DECISION DELEGATED TO DEVELOPMENT MANAGER

Application No: H16-0960-18 **Applicant:** Centric Homes Ltd

Proposal: Erection of bungalow, including the demolition of existing industrial premises

Location: Land: 2 Carrington Road Carrington Road Spalding

08 / 1 - Proposed Ground Floor Schedule		
Name	Area	Perimeter
A.C / Store	1.60 m²	5.5 m
Bath	6.80 m²	10.6 m
Bed 1	12.30 m²	14.2 m
Bed 2	11.45 m²	14.1 m
Bed 3	8.55 m²	12.6 m
Entrance	9.35 m²	15.8 m
Open Plan C.E.L	38.85 m²	28.5 m
Grand total: 7	88.95 m²	101.2 m

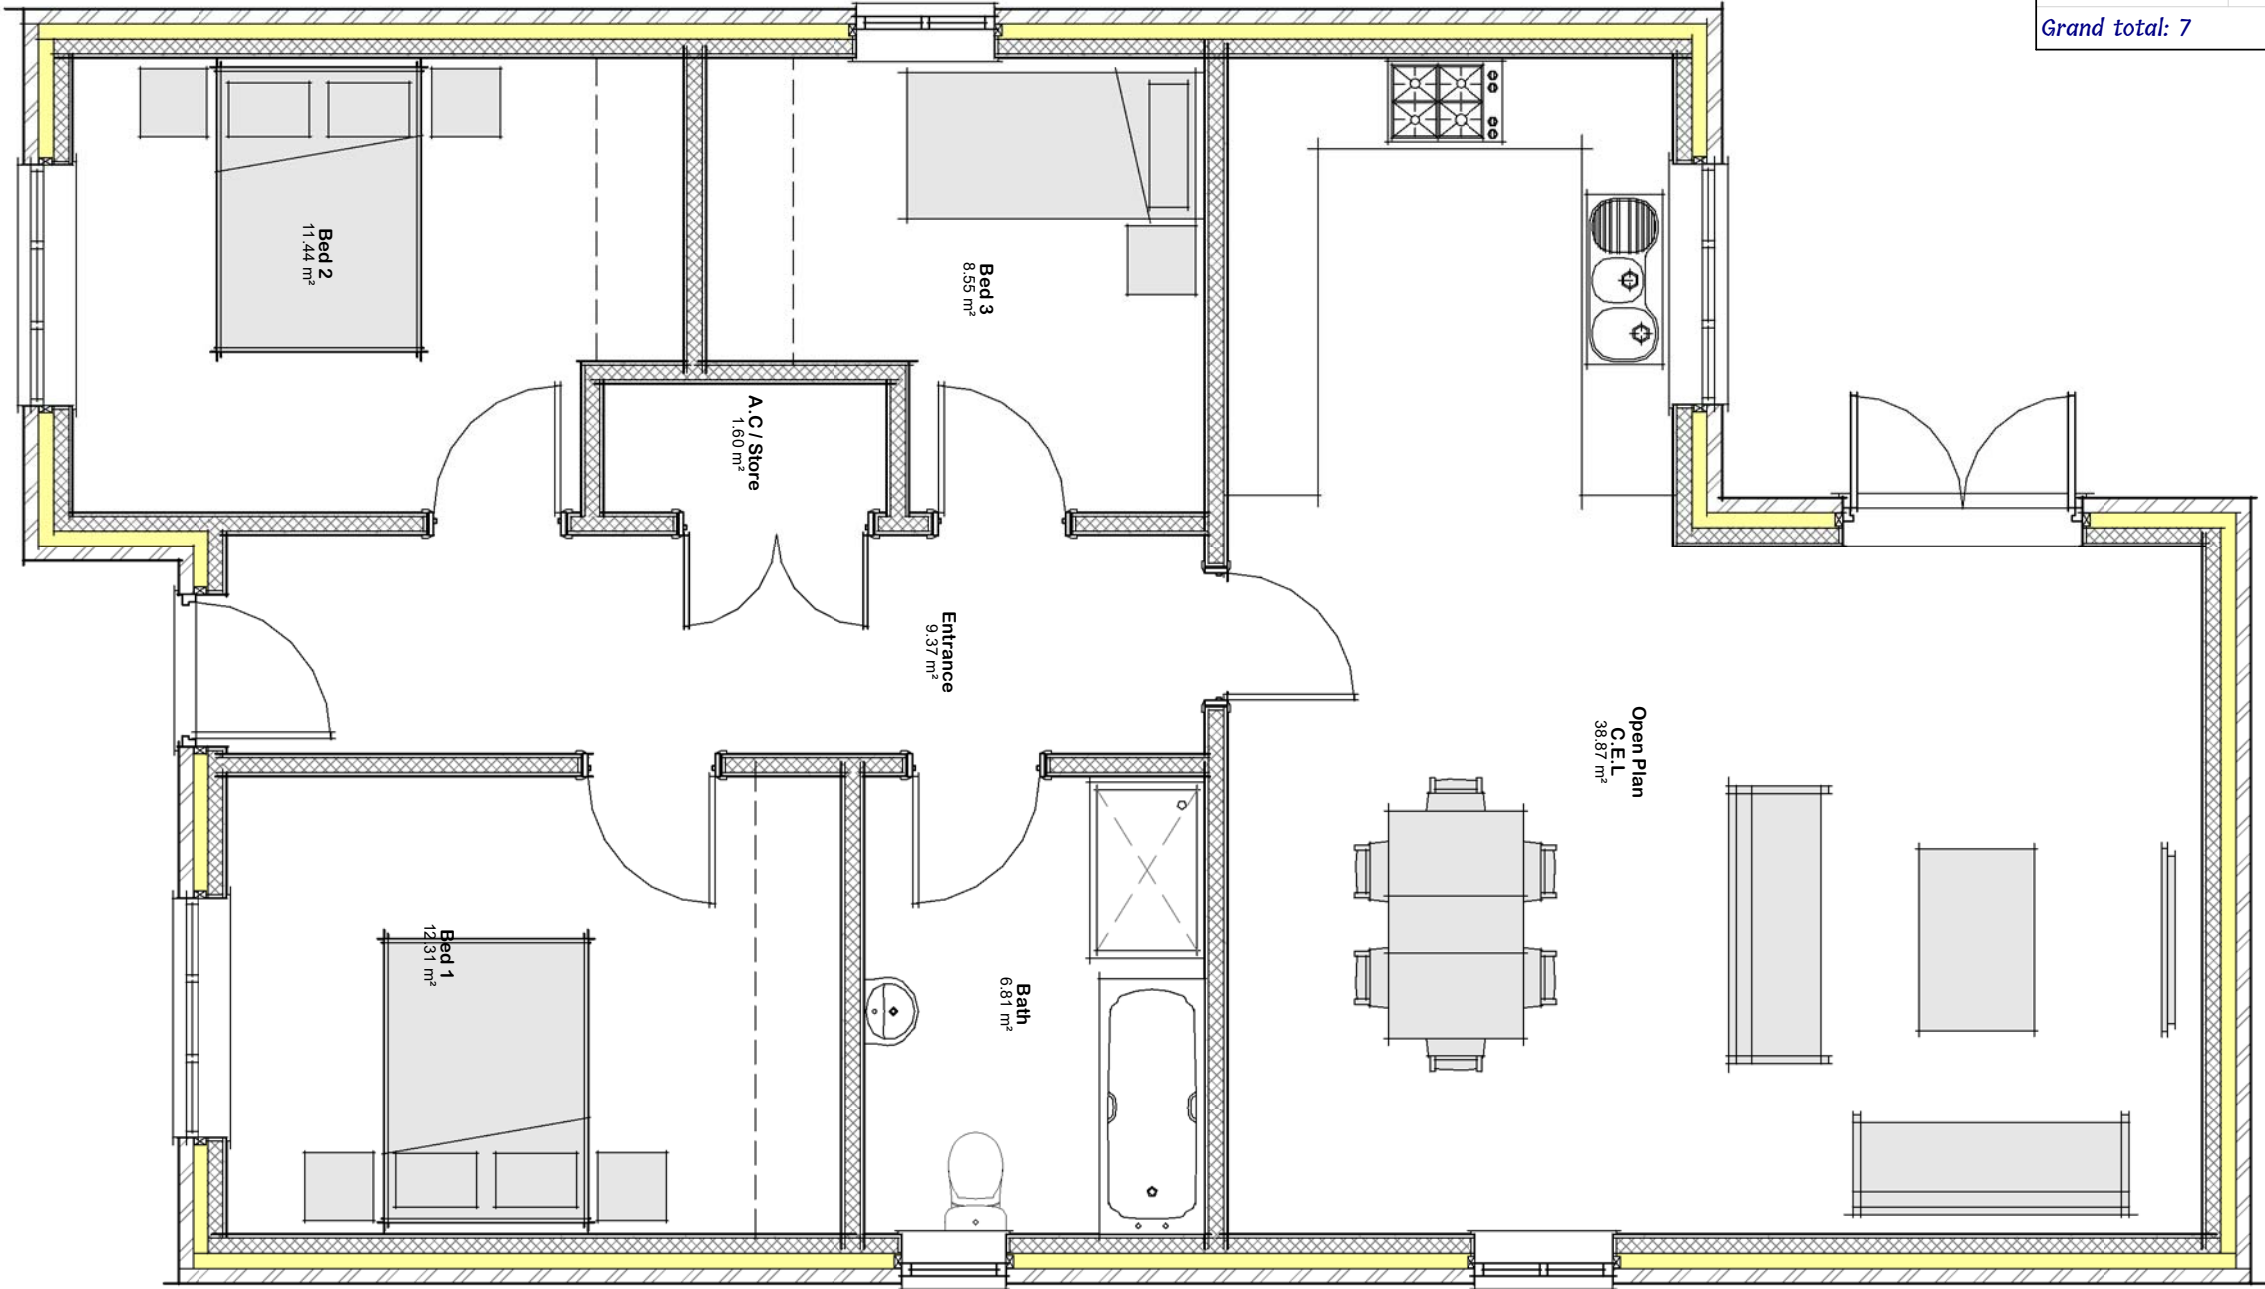
Furthermore, the proposed dwelling would appear cramped within the plot compared to existing dwellings in the vicinity, being just 0.6m from the south-eastern boundary and no more than 1.3m from the north-western boundary.

In addition, the site is restricted in size and so the new dwelling would have little by way of beneficial outside amenity space. It would therefore not offer future occupants an acceptable standard of amenity.
